Response to Applicant's video of drive-through of proposed route for construction traffic

Drawing Title
Indicative Construction Access and Compounds
Sheet 2 of 5

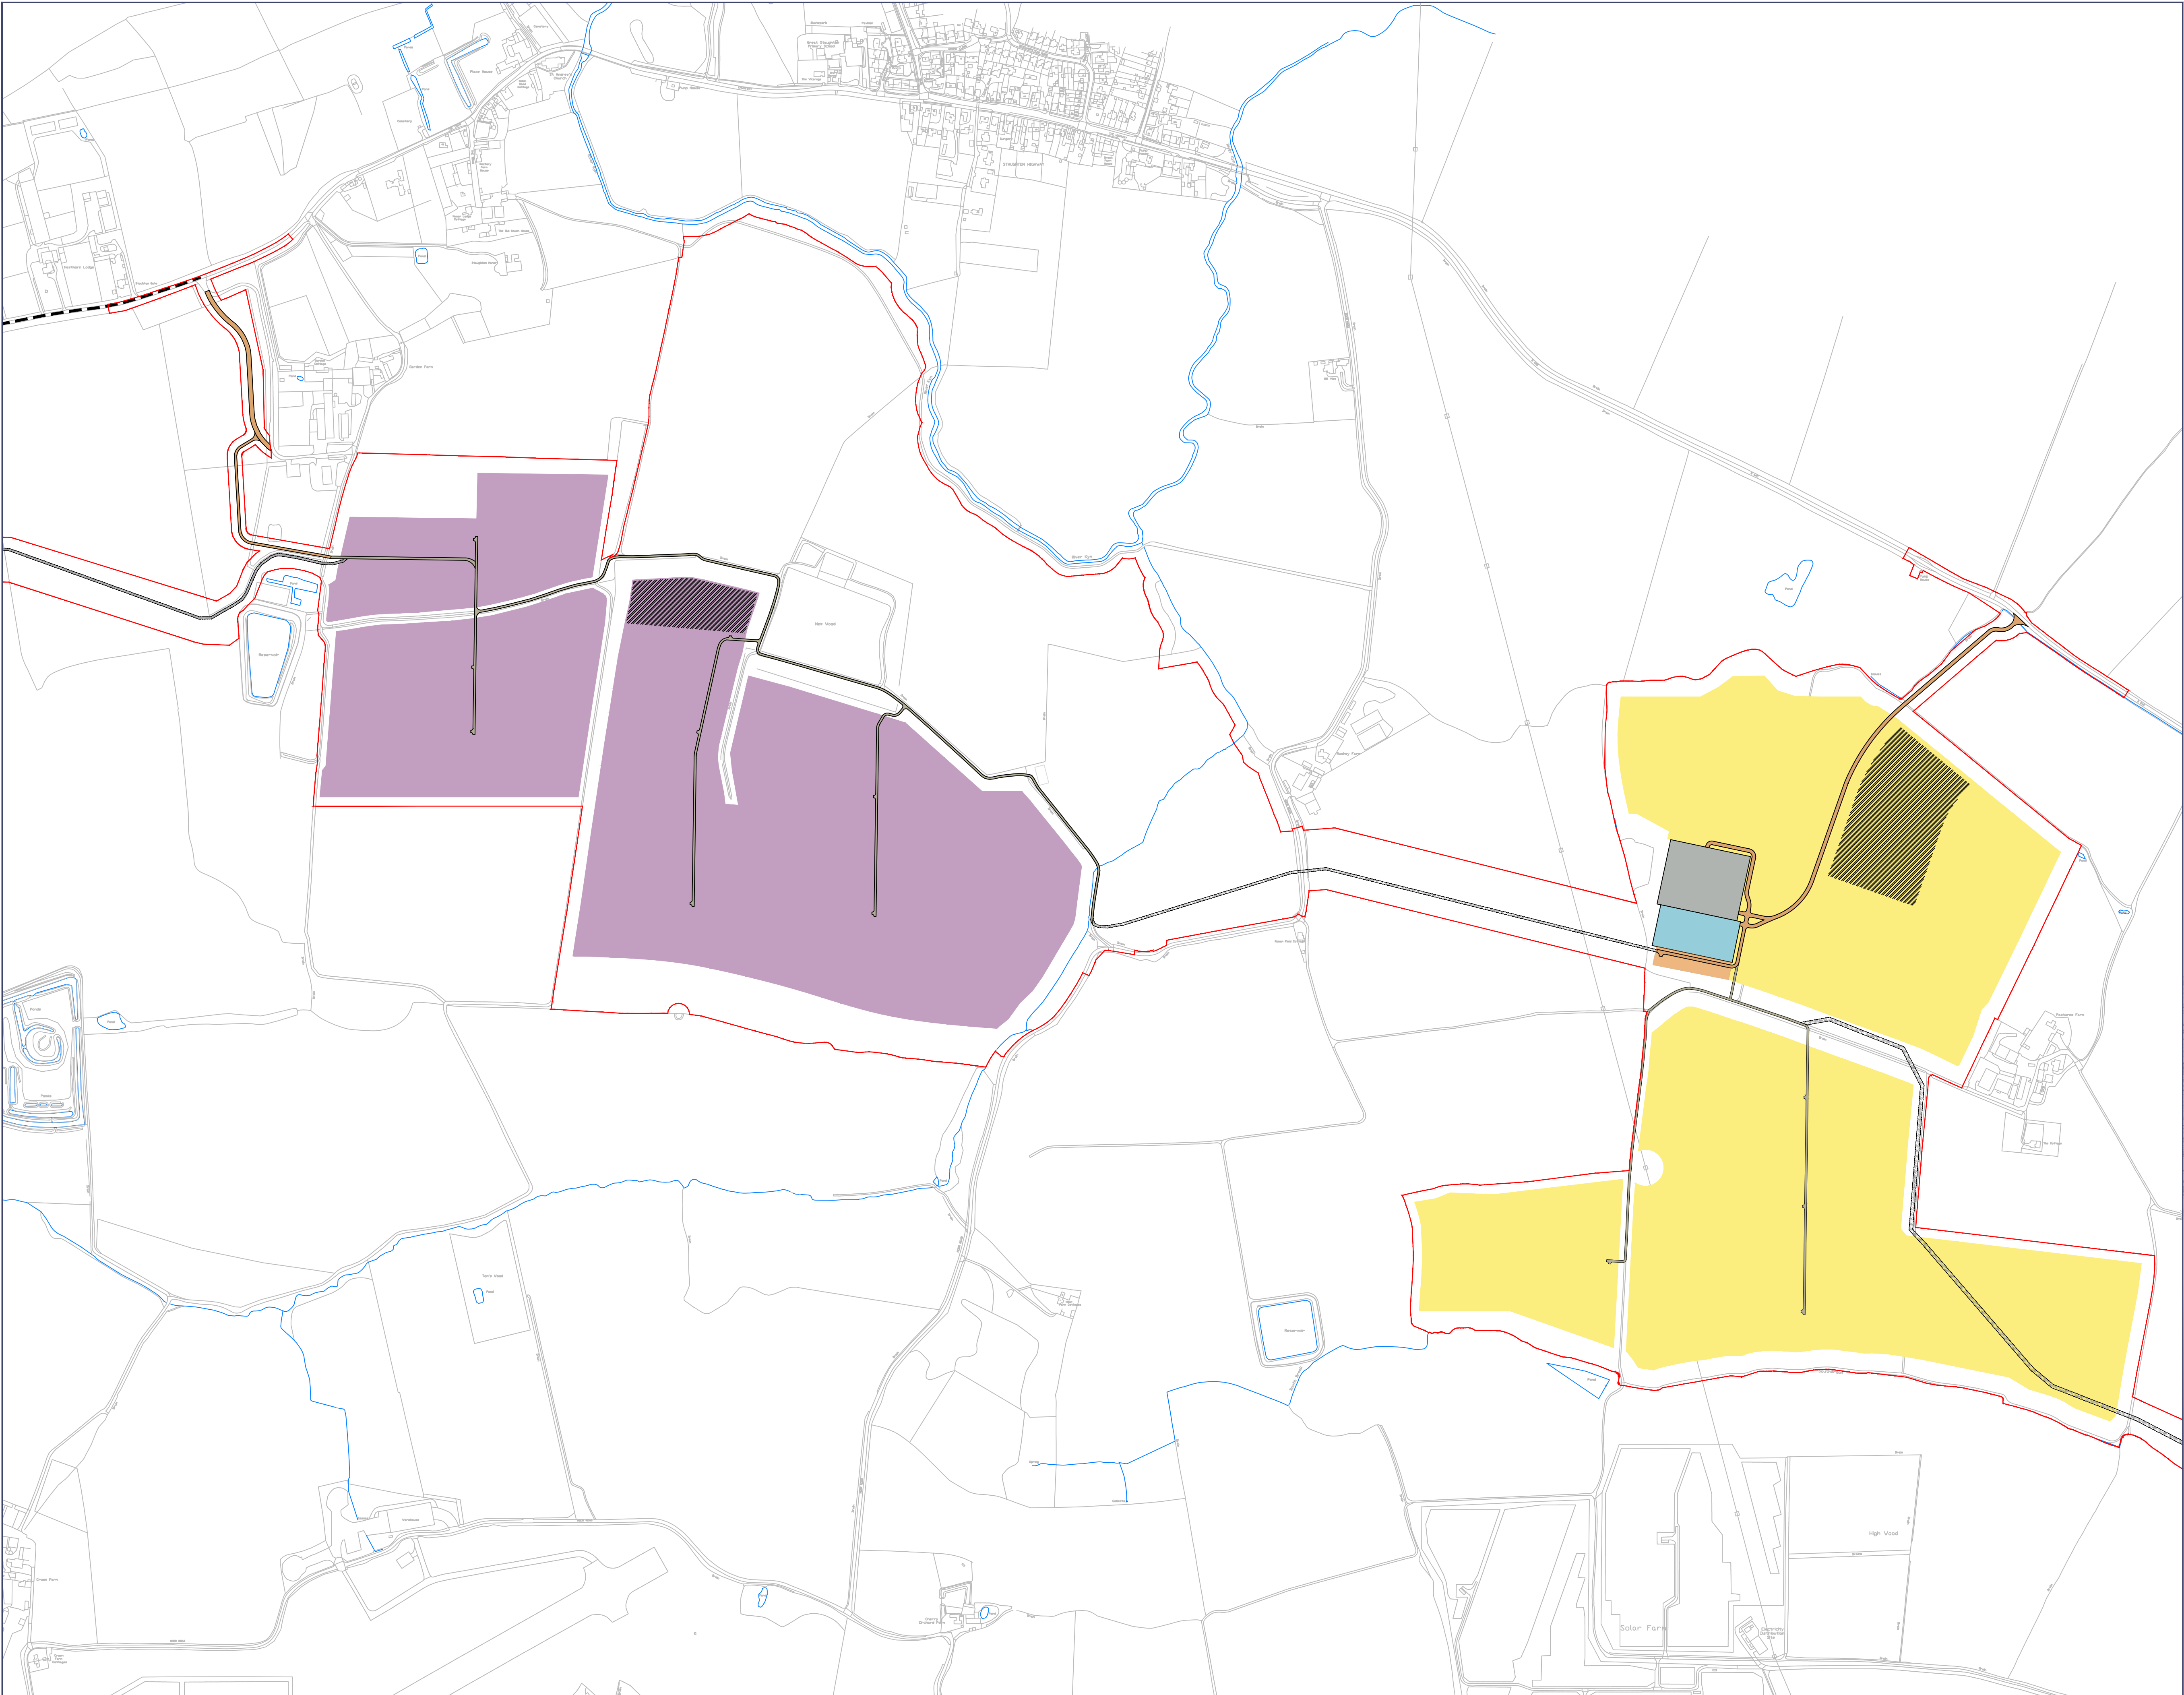
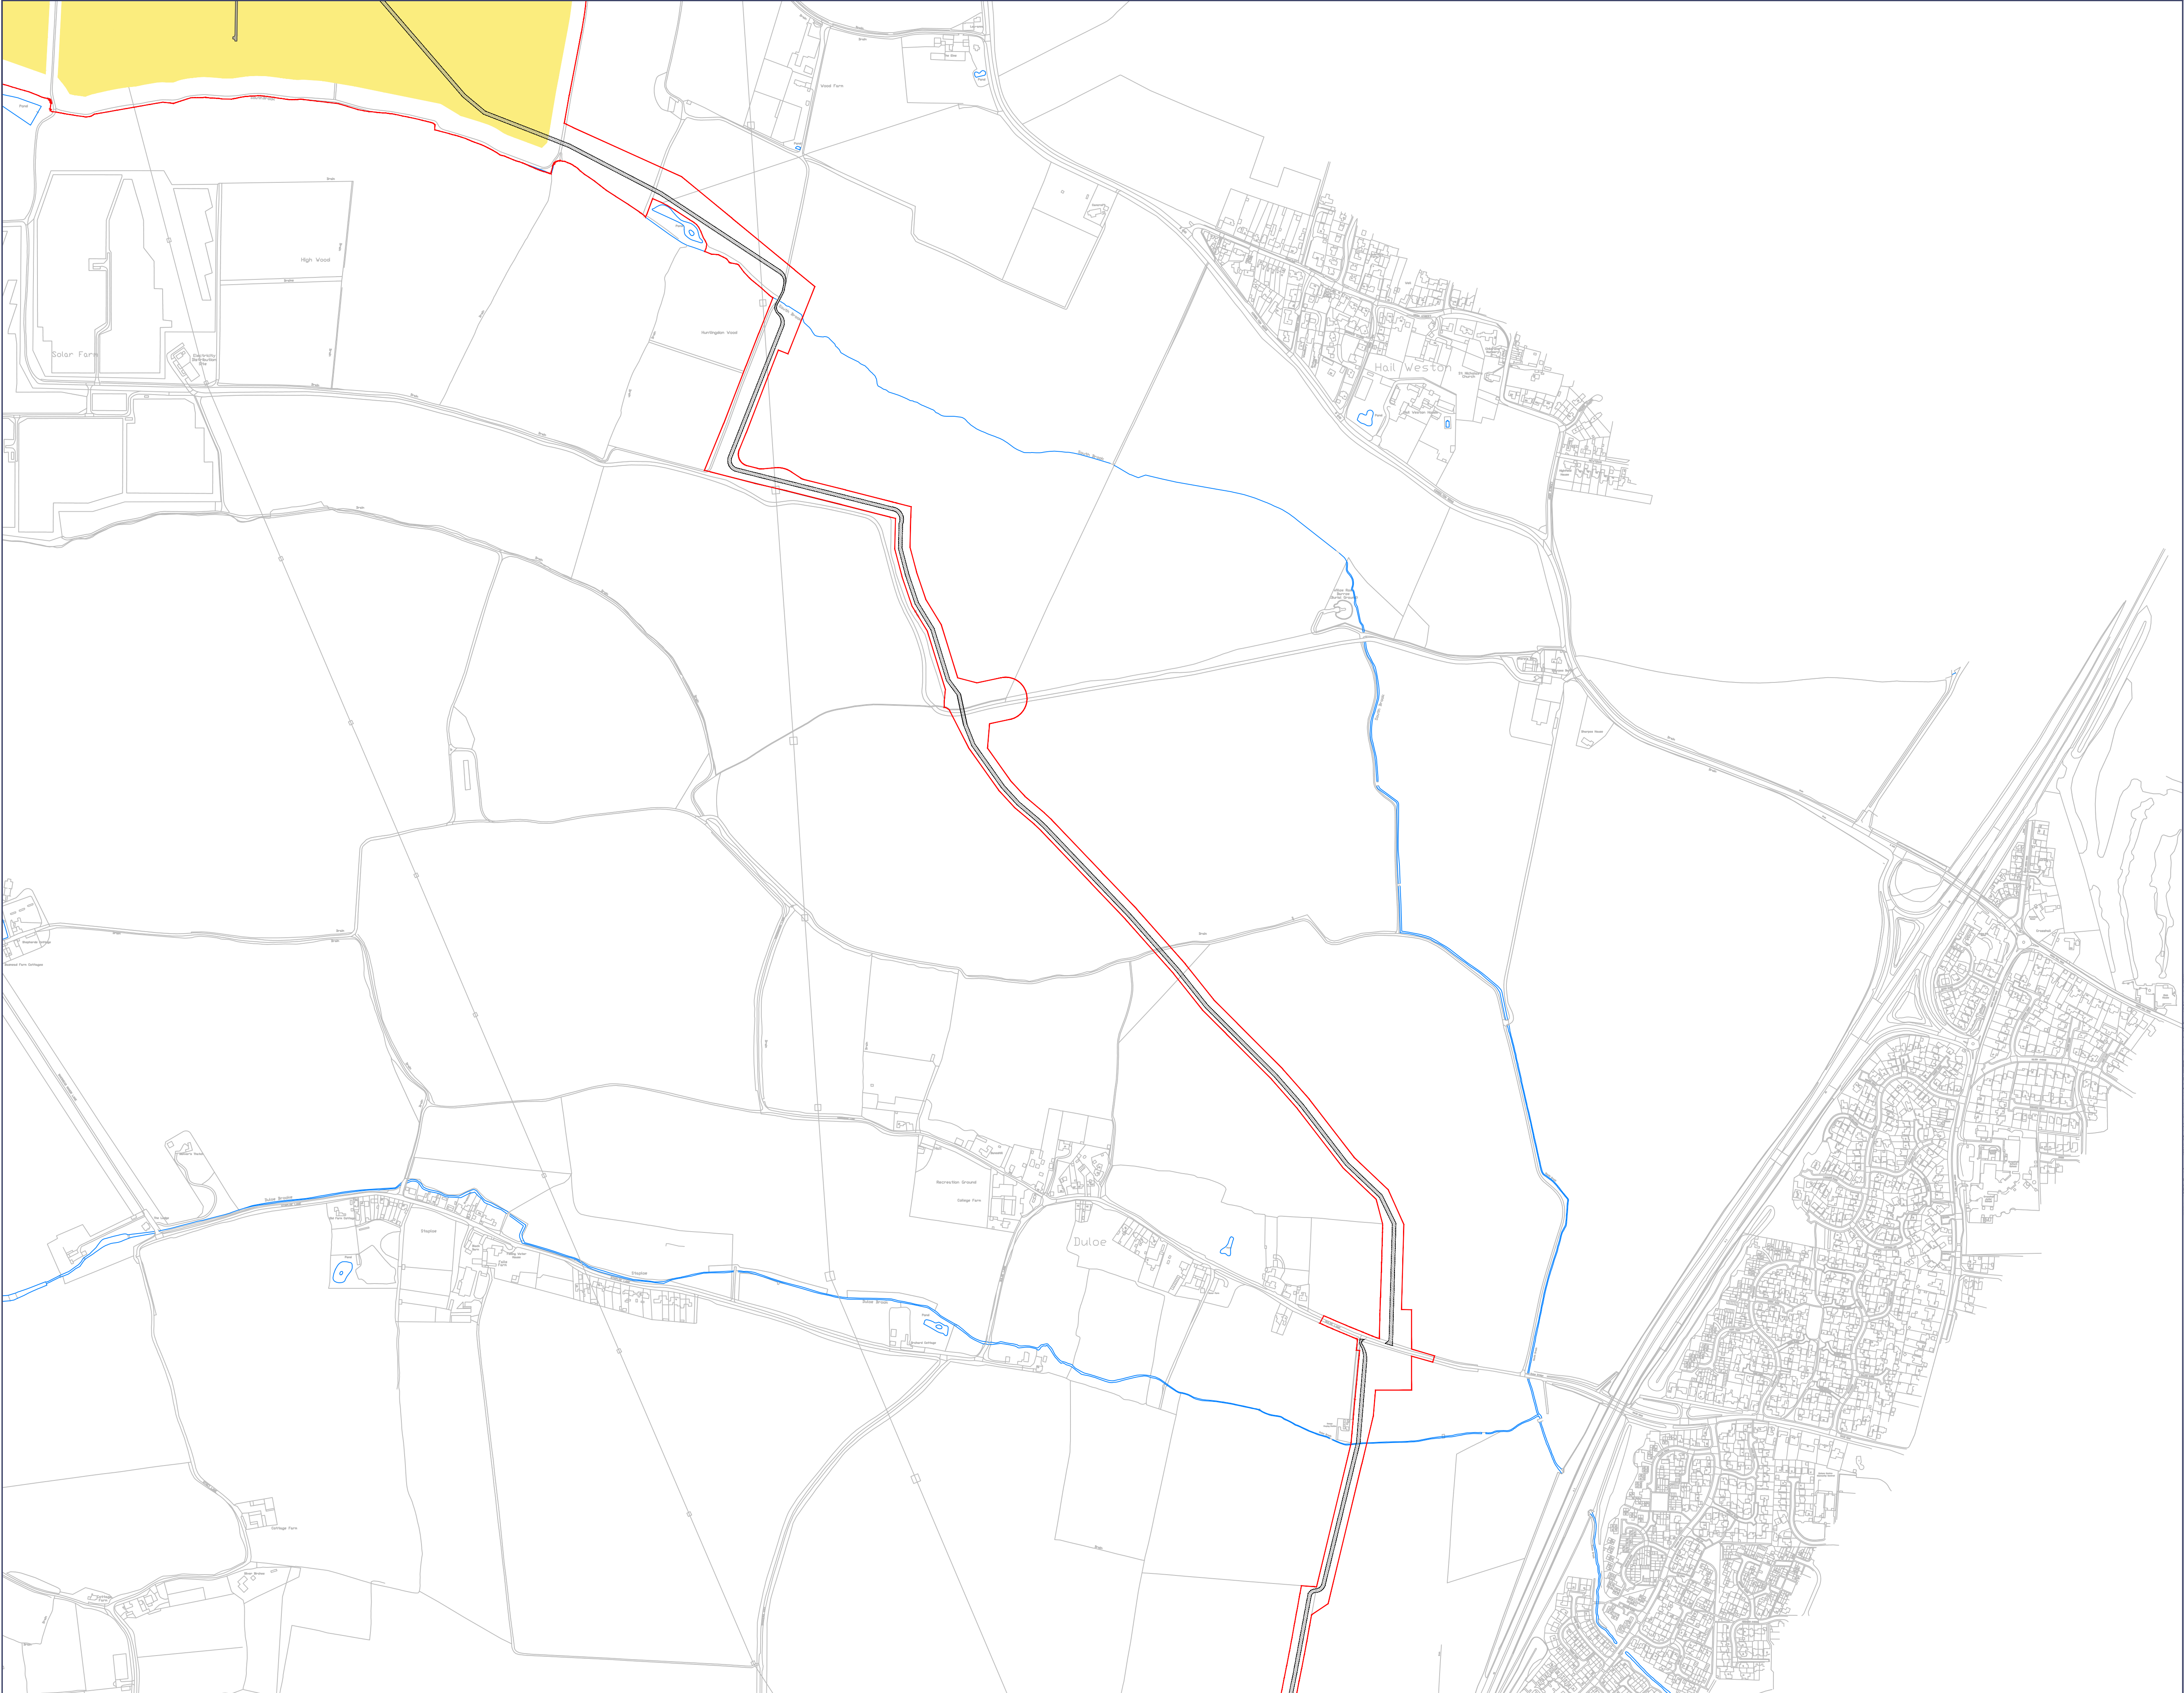
- Making the video from a HGV would have given a far more realistic view of the impact of the bends, hills and junctions that will be encountered by such vehicles during construction that may not be evident from a car.

- An indication of the time of day this video was filmed would allow a better estimation of the effects of peak traffic volumes at different times of day.

- The mileage and number of local highways being used is far greater than expected. This contradicts the Applicant's claim that constructing a temporary road network across the fields would eliminate disruption to local residents!

- Routes that will be used by HGVs during the operational stage when the temporary internal road is no longer available should also be shown as this impact will not be "insignificant".

- As HGVs and workers are only being "encouraged" to use these routes, driving routes to the different areas using only GPS guidance would show the potential impact of likely alternatives/short cuts. This would give a much more realistic portrayal of the unsuitability of the local road network which will be impacted by this scheme.
